**Our Ref: FP/179/12/
Your Ref:**

Application for Planning Permission for Works or Extension to a Dwelling

Development Single storey side extension & front garage extension with internal alterations (re-submission following refusal FP/62/12/)

Location 42 Golf Links Road Felpham

SITE LOCATION & BLOCK PLAN.			
Scale	1:1250 1:500 @ A3	Drawn By	C.R.B.
Date	MAR. 12.	Checked	K.E.H.
Drawing Number	4781/1.B

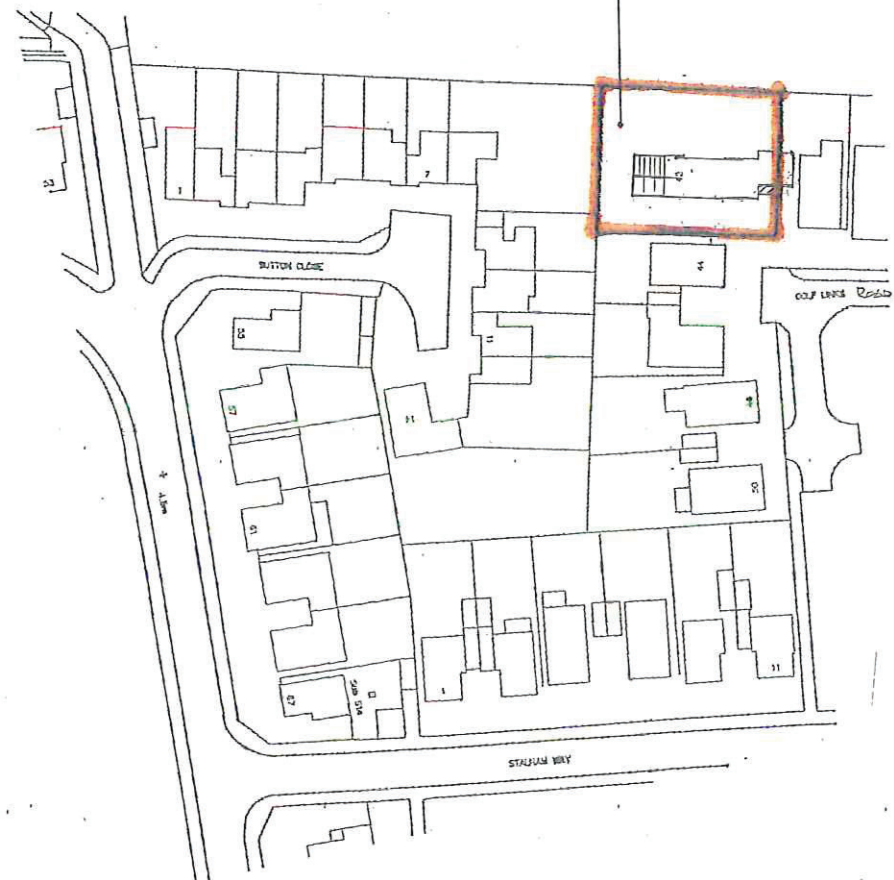
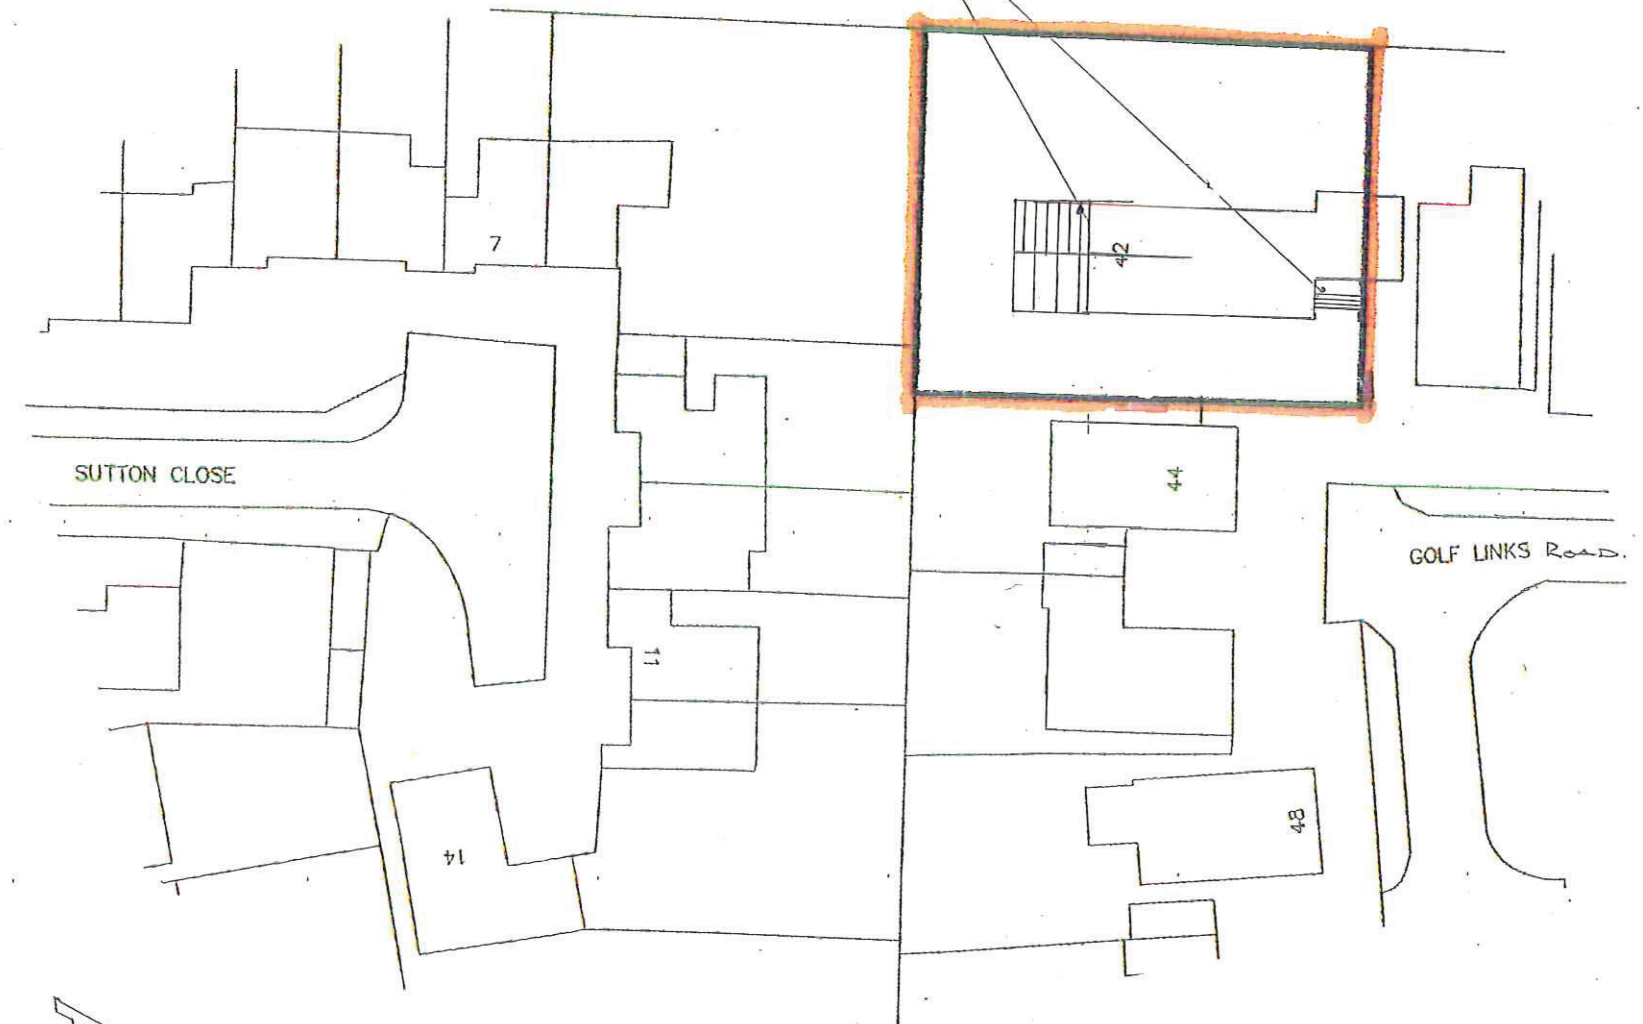
Please submit 1 electronic or 3 paper copies of a revised location plan clearly showing 2 named roads (the road names provided are unclear) in accordance with the guidance notes available on our website detailed below (click on National List).
